Our ref: HMS ID 12088

Advice on Environmental Impact Statement – State Significant Development

Proposal: Berrima Hotel/Berrima Correctional Centre

Major Project reference: SSD-66876472

Photomontage of the hotel building as viewed from the River (Source: Architectural Design Report prepared by Turner (page 155))

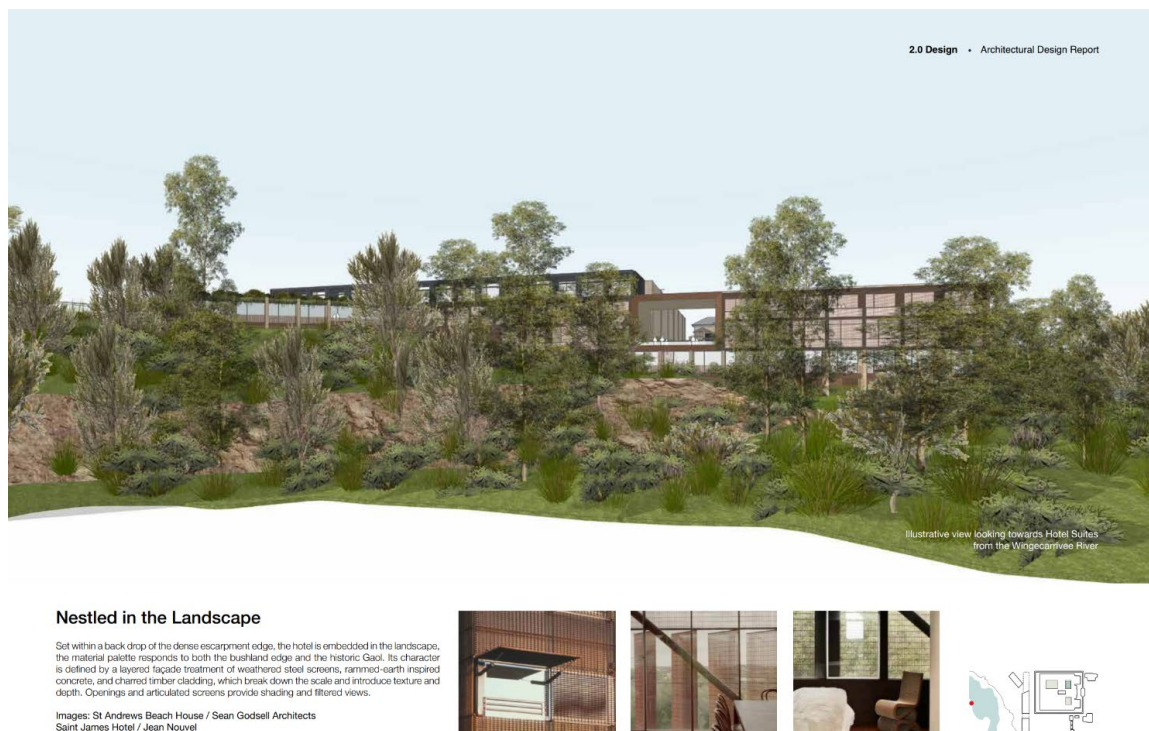
- 6. The *Visual Impact Assessment* does not assess visual impacts from viewpoints along the Wingecarribee River. We recommend visual impact assessments be undertaken from key viewpoints along the river, including viewpoints from any State heritage items within the view catchment of the SSD.
